Application no: **3/2023/0410**

Address: **Cunliffe House Farm Longsight Road Langho BB6 8AD**

Proposal: **New single storey detached building to be used as a fire/stove showroom along with parking spaces.**

The Local Highway Authority have viewed the plans and highway related documents and have the following comments to make:

Proposed Site Plan 1:200

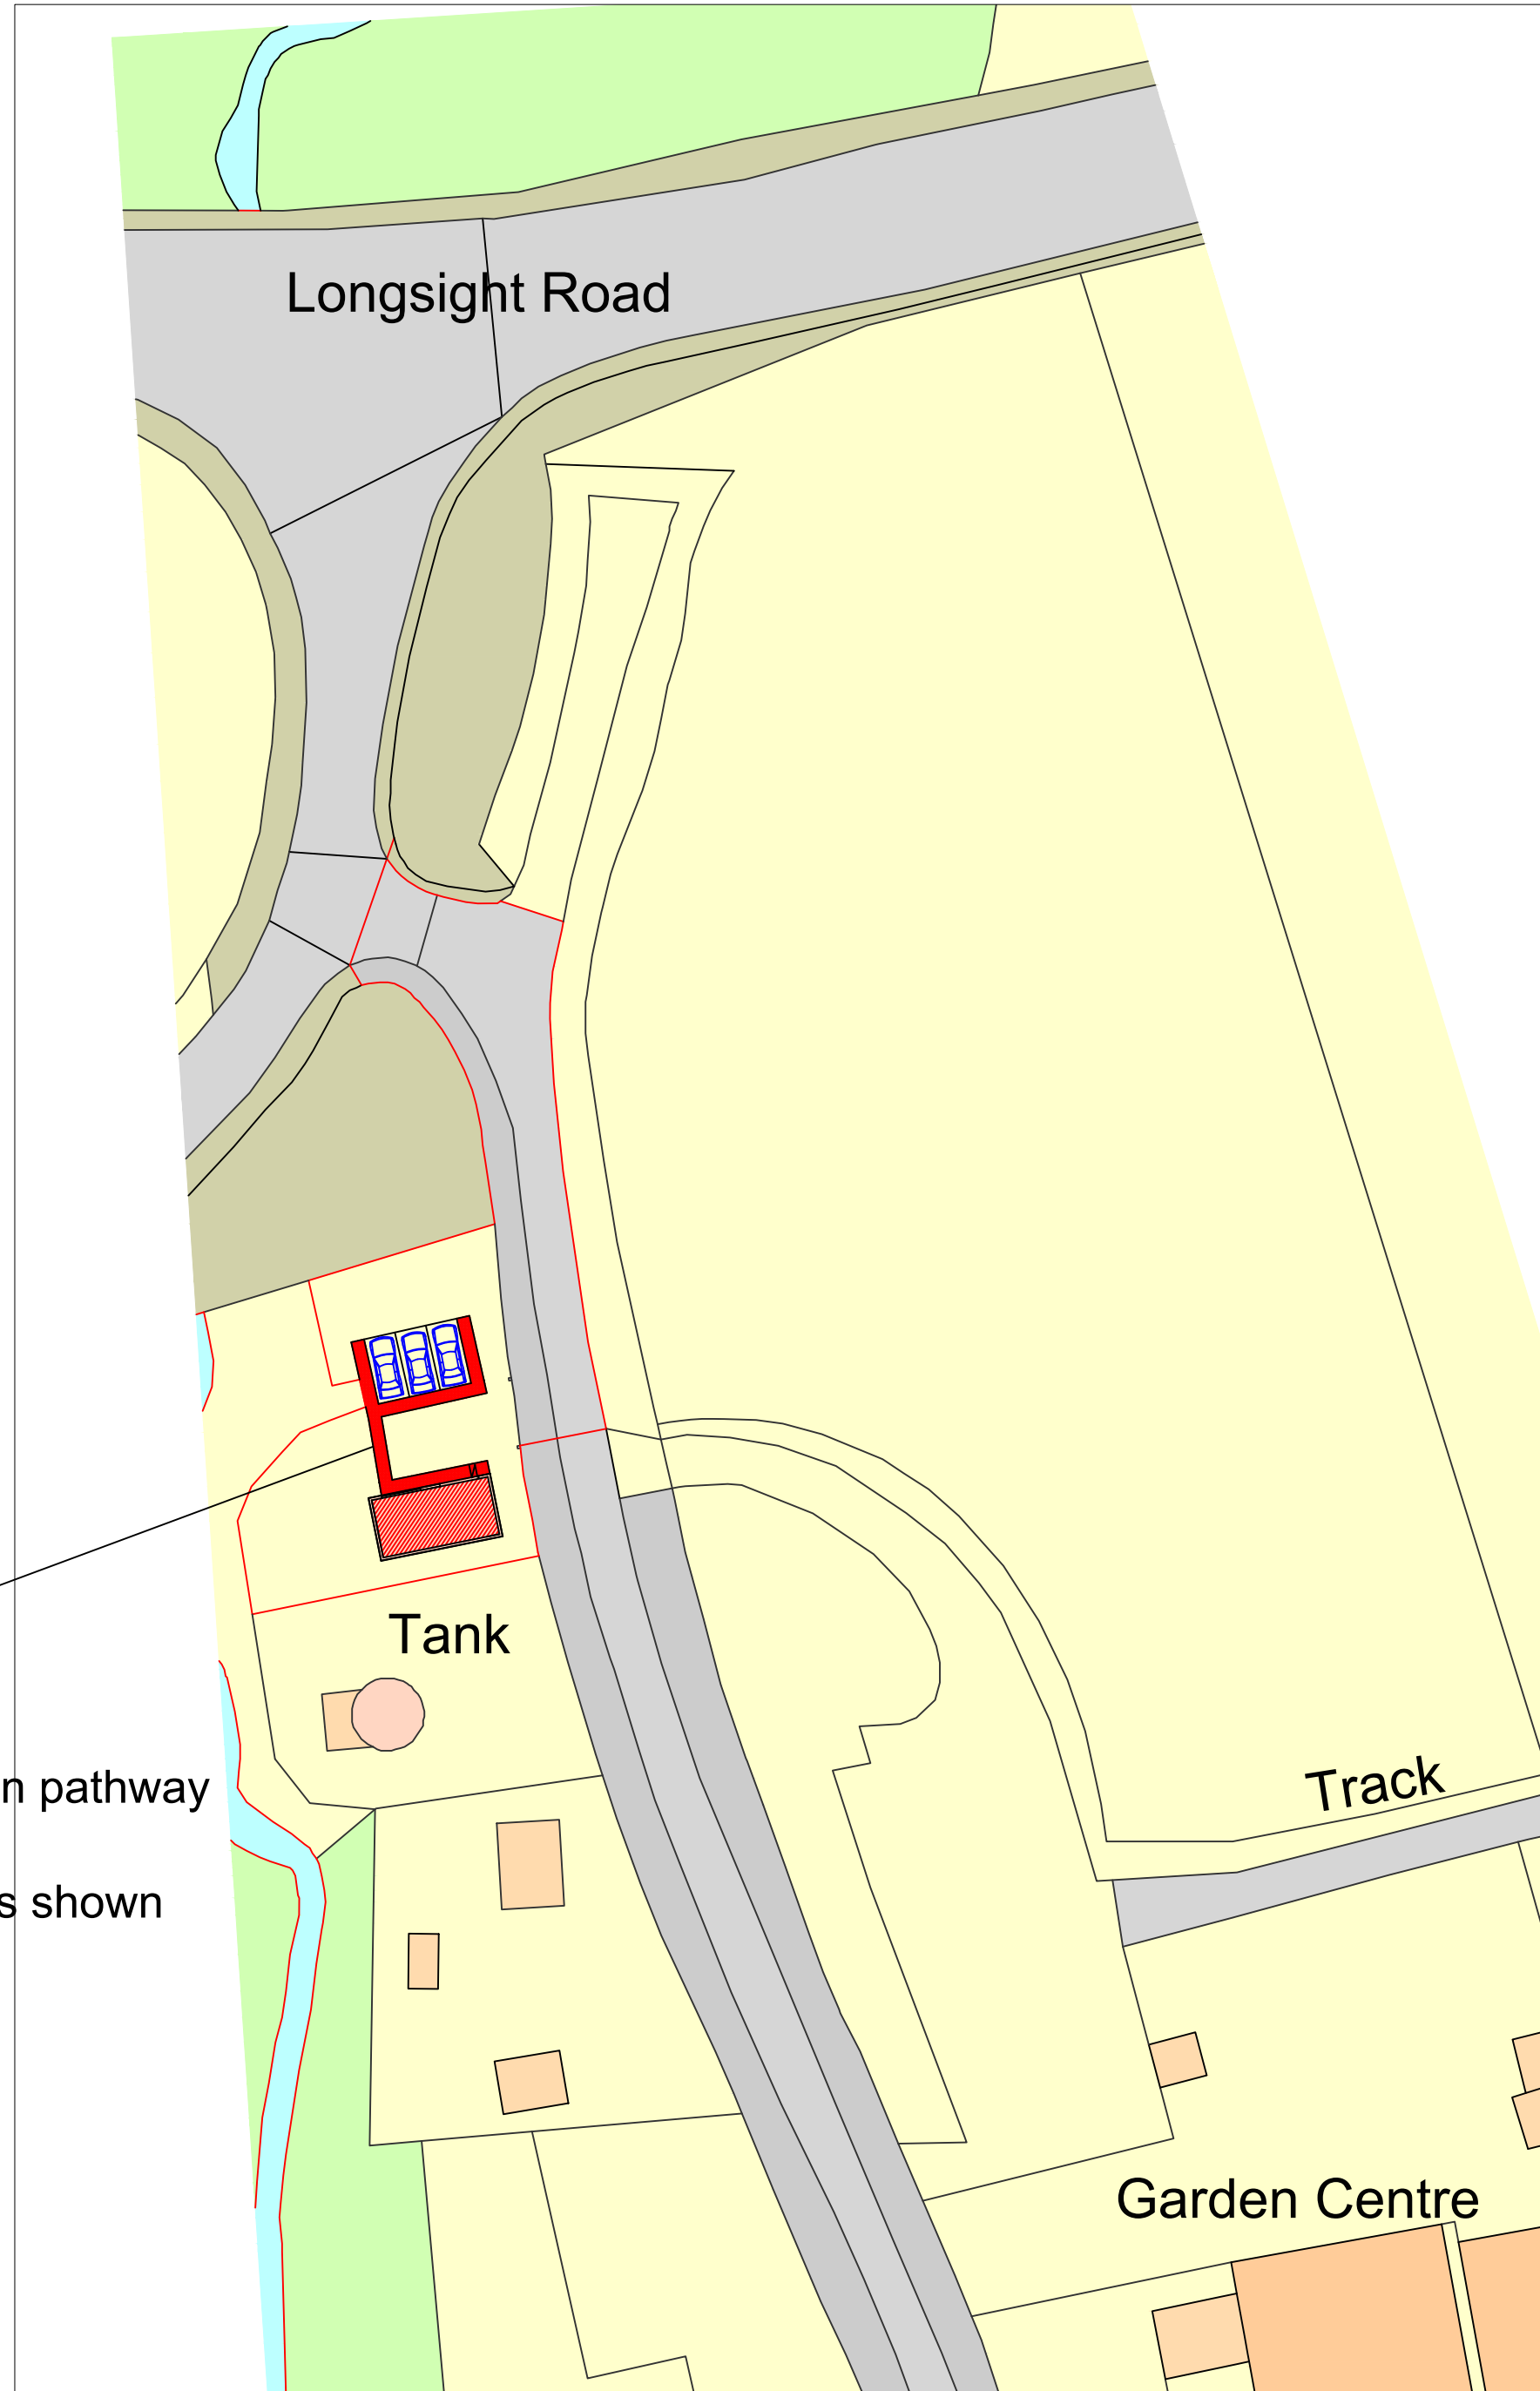
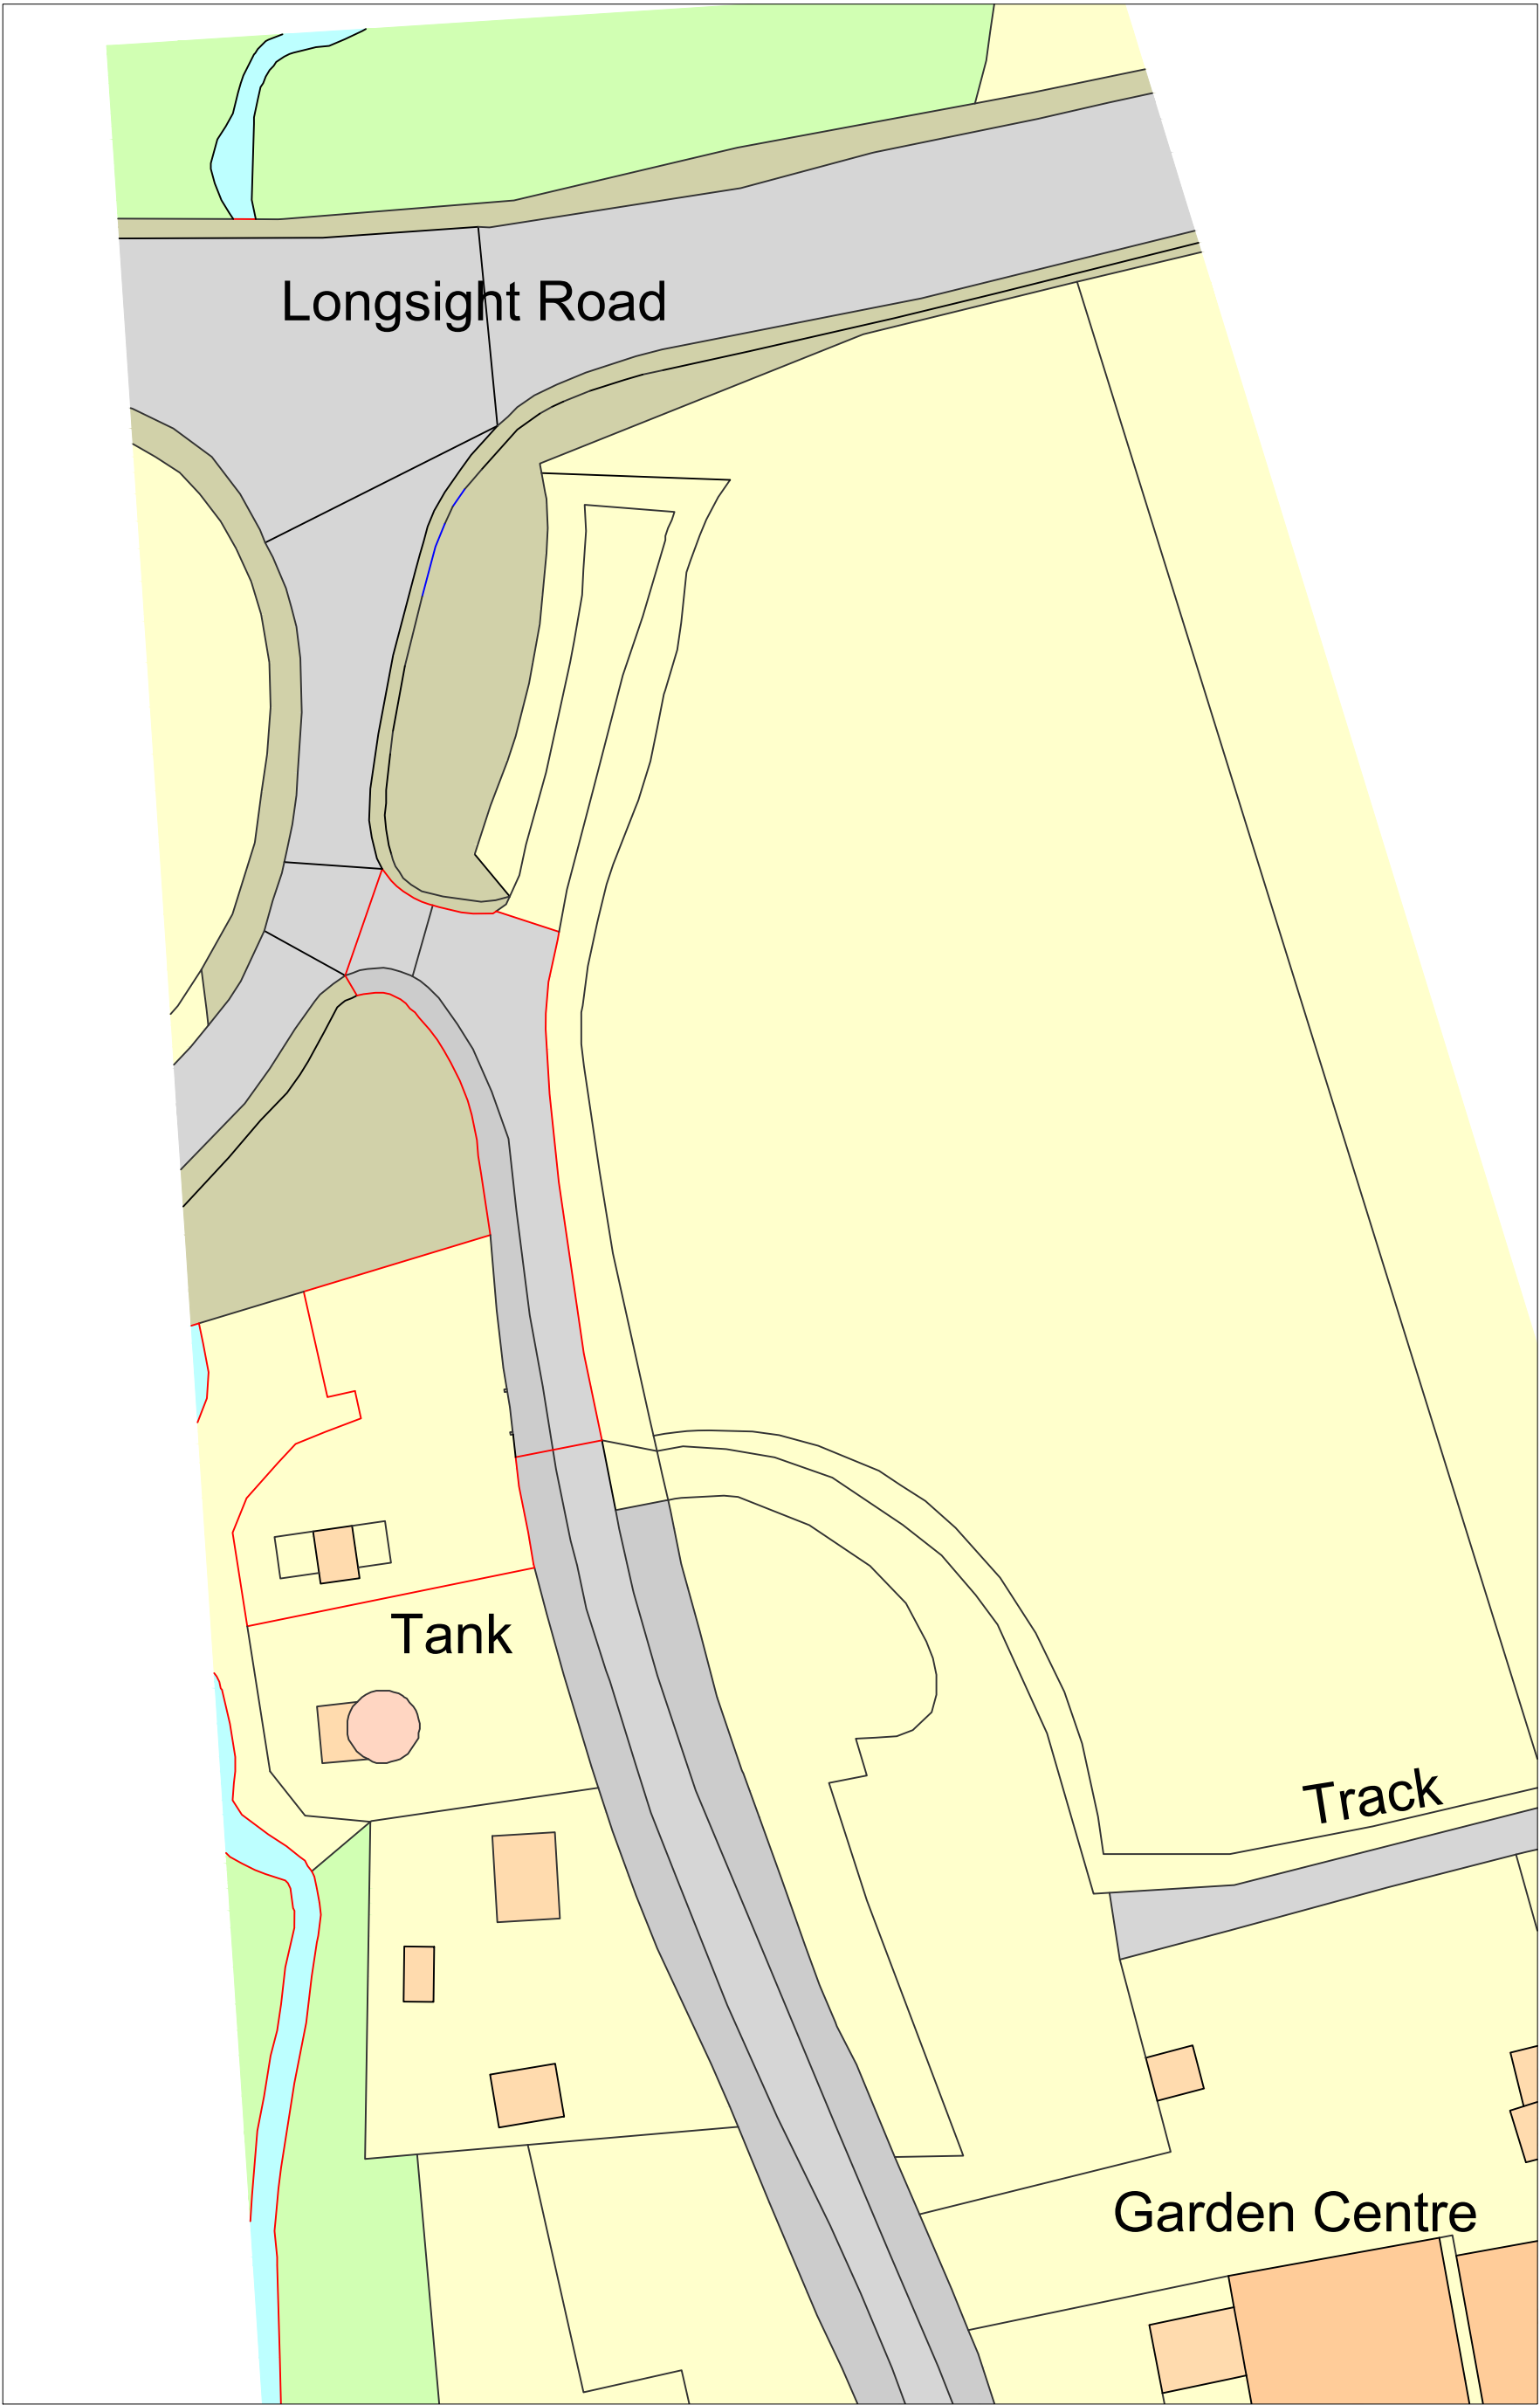
The LHA also require further information in the guise of an internal site access plan. The LHA require an internal site access plan showing the access to the proposed showroom. Currently no information has been submitted regarding the access width and so to ensure that the access is safe and suitable for the public, the LHA request a plan is submitted.
